Application no: H16/0565/03

Description: Erection of overhead illuminated projecting sign

Location: 25 Bridge Street
Spalding

Amendment: Projecting sign now overhead illuminated
Dwg no. Sheet 1 of 1 Revision A

OVER-HEAD ILLUMINATED PROJECTING SIGN 1:20

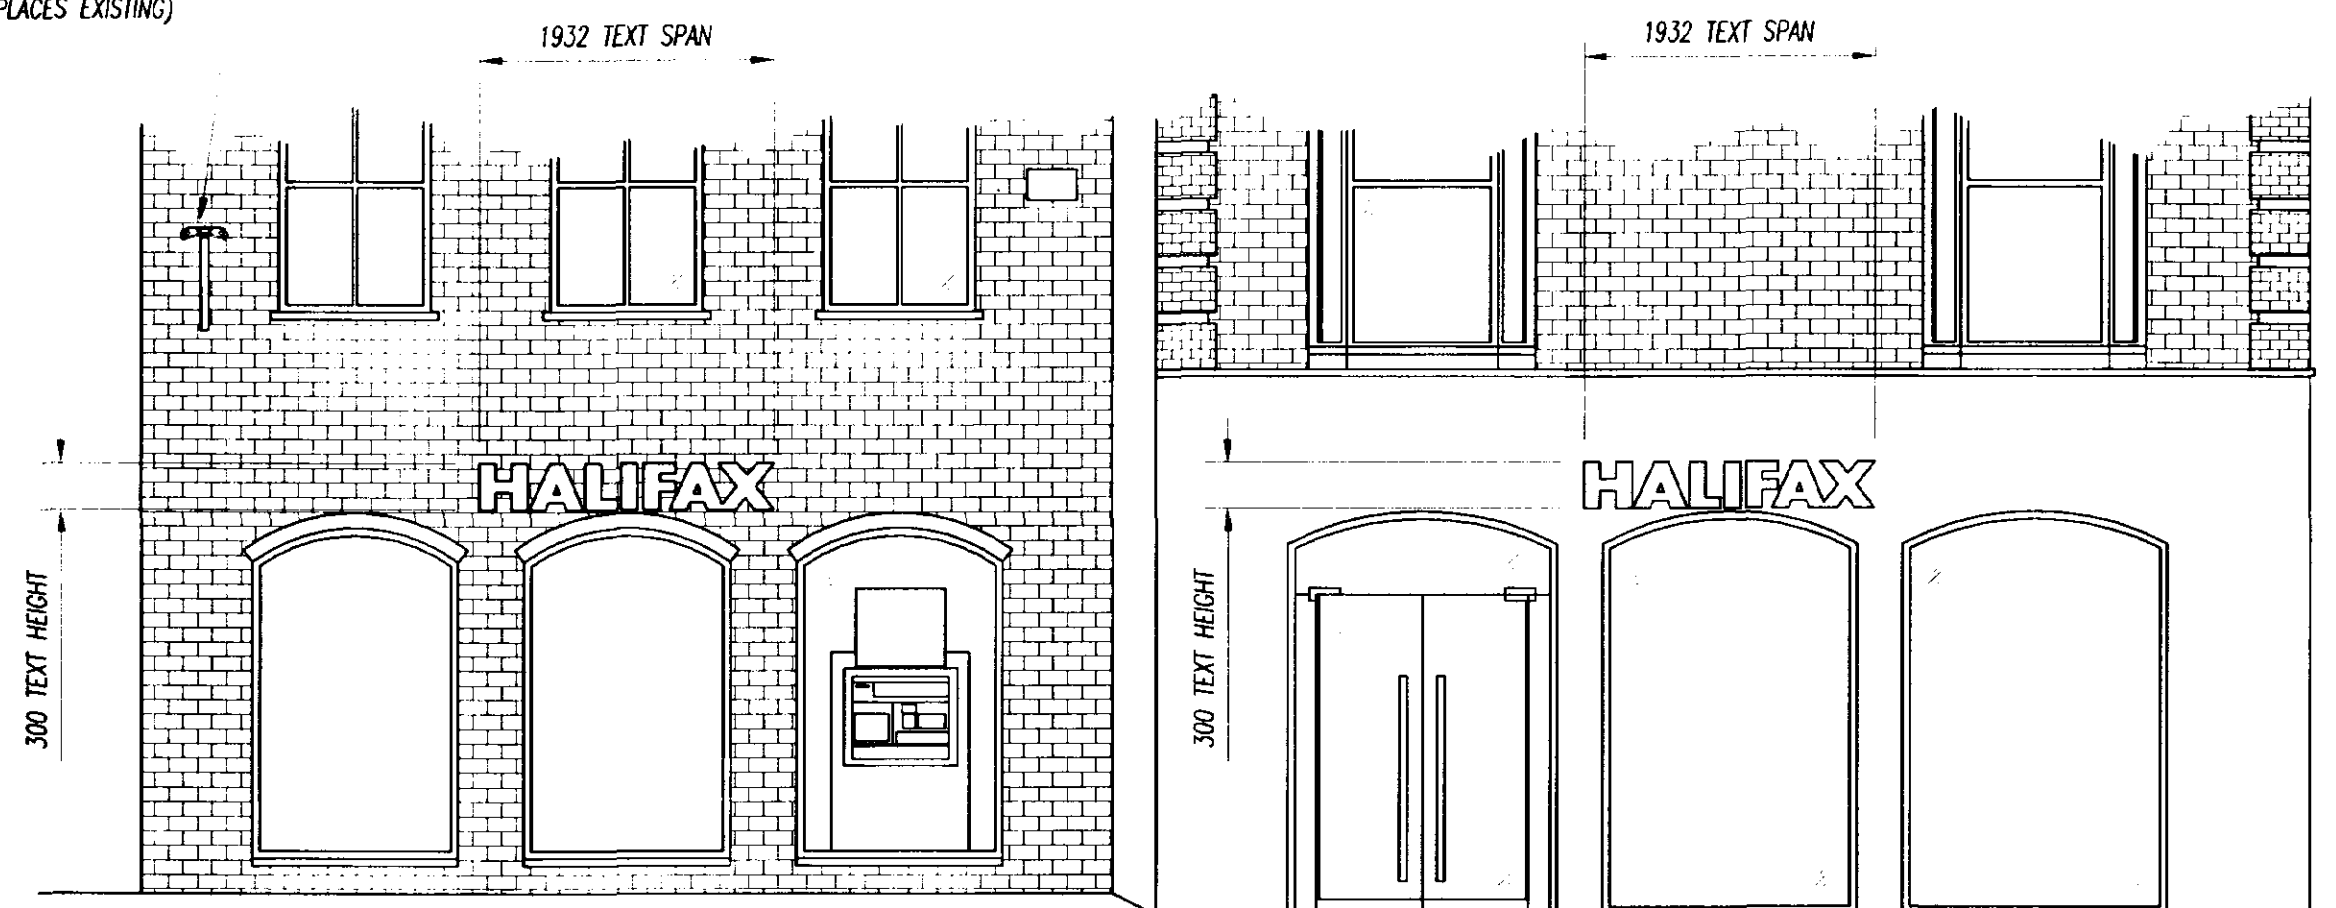
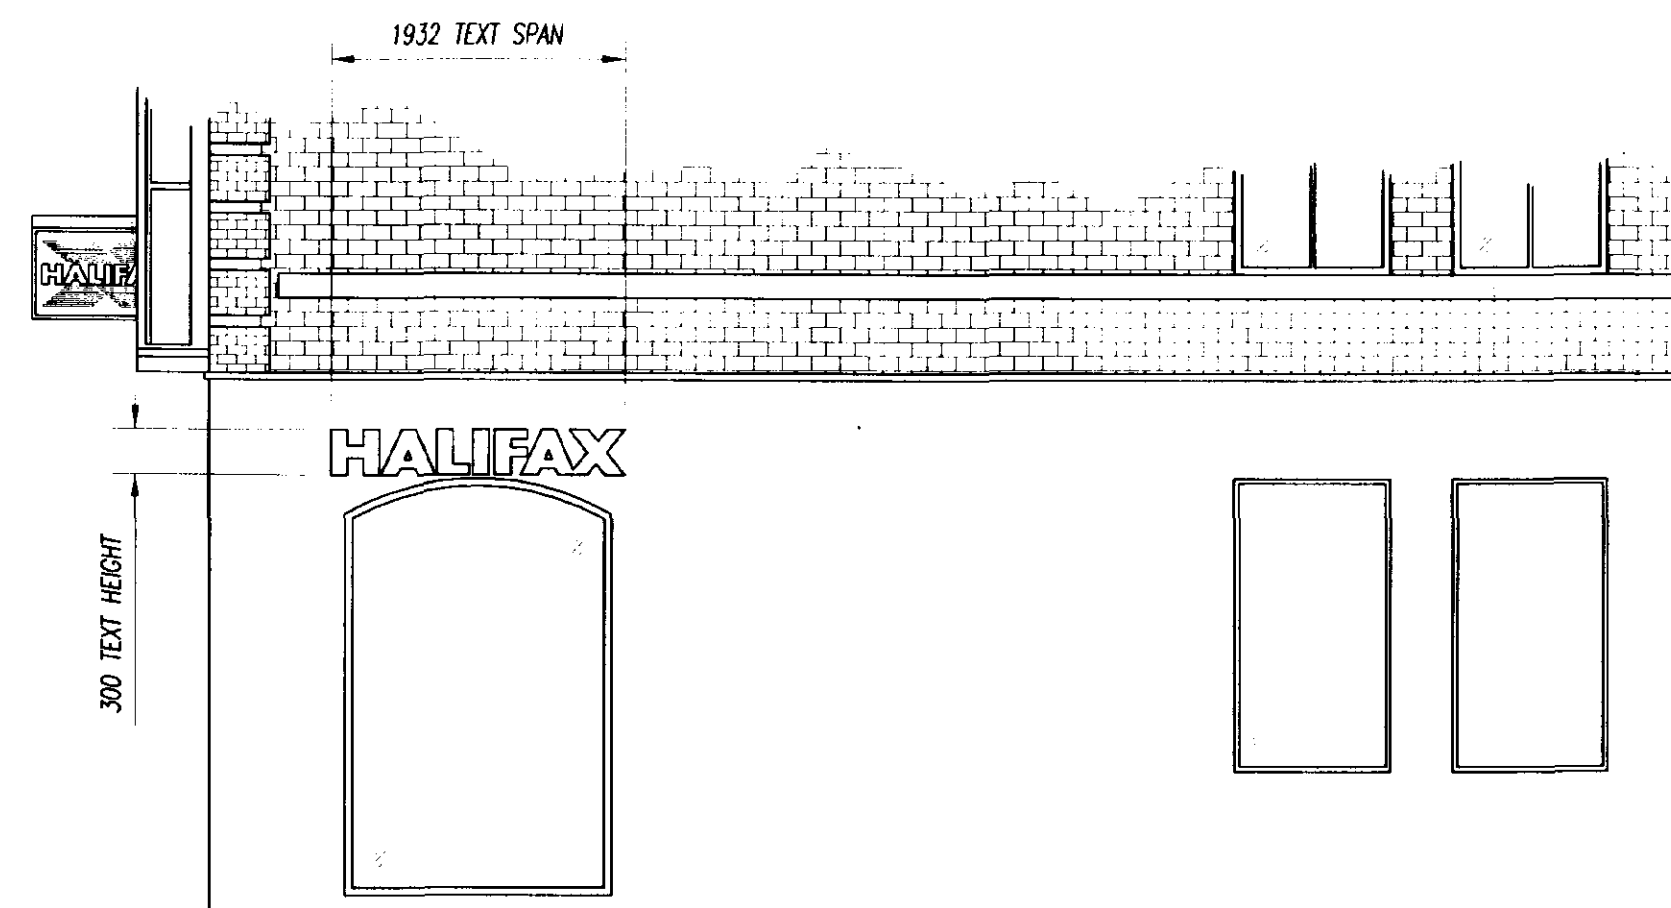
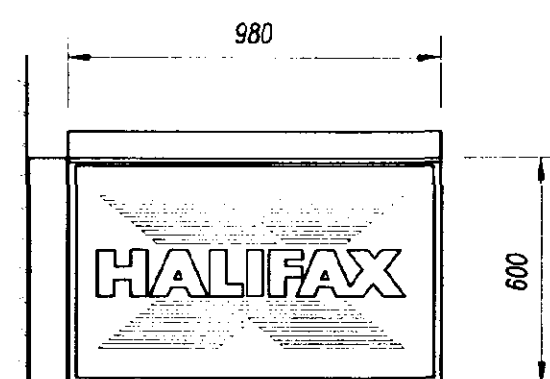
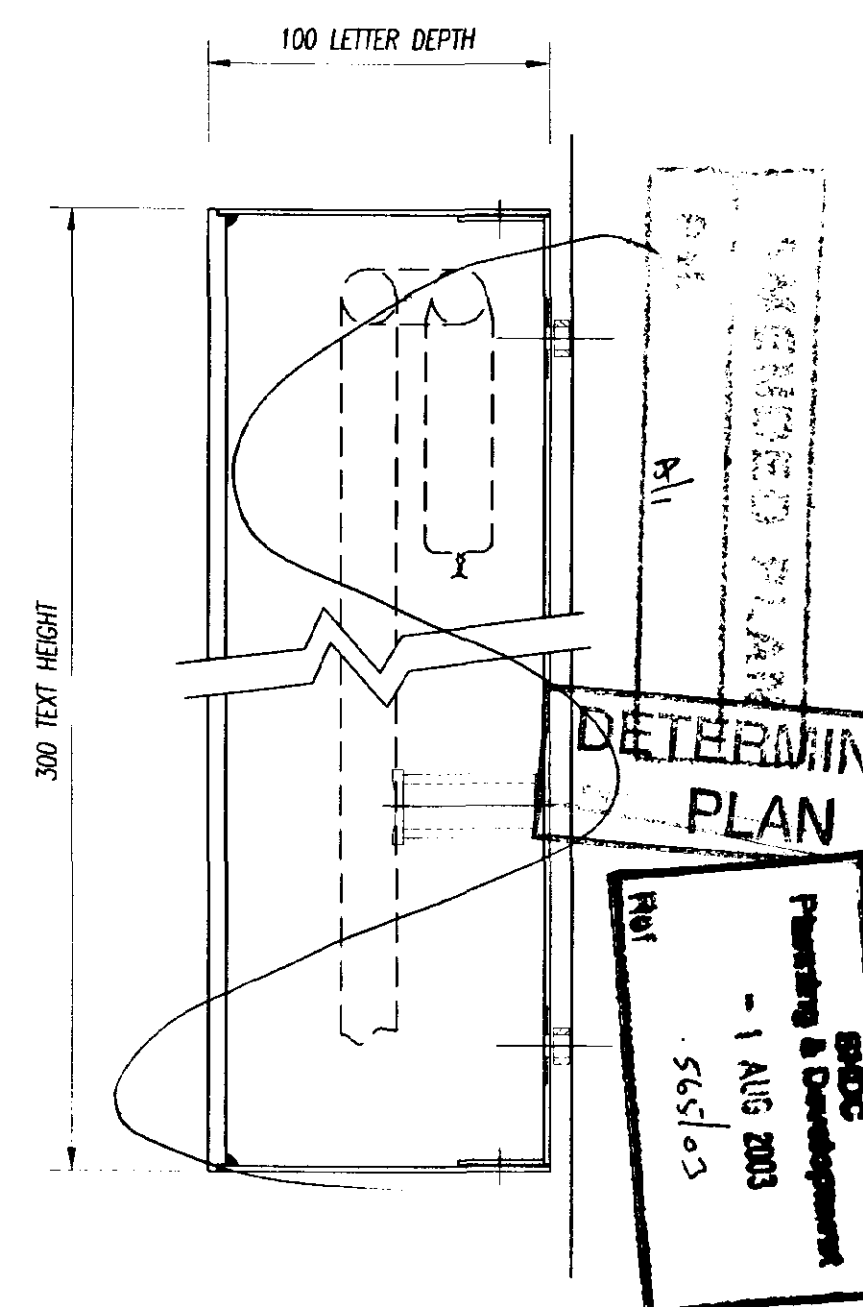
The application is for an internally illuminated projecting sign to replace an existing internally illuminated projecting sign on the building. However, since the original application was considered the Council's Planning Policy in relation to advertisements has changed to prevent such signage within the conservation area. I therefore write to suggest that the design of the sign is changed so that it is externally illuminated with narrow strip lighting concealed at the top of the sign. I enclose amendment forms for you to complete and return with your amended drawings as soon as you are able.

Further to your letter dated 24th July, we enclose herewith our revised drawings showing the projecting sign now overhead illuminated.

PROJECTING SIGN
NOW OVERHEAD
ILLUMINATED
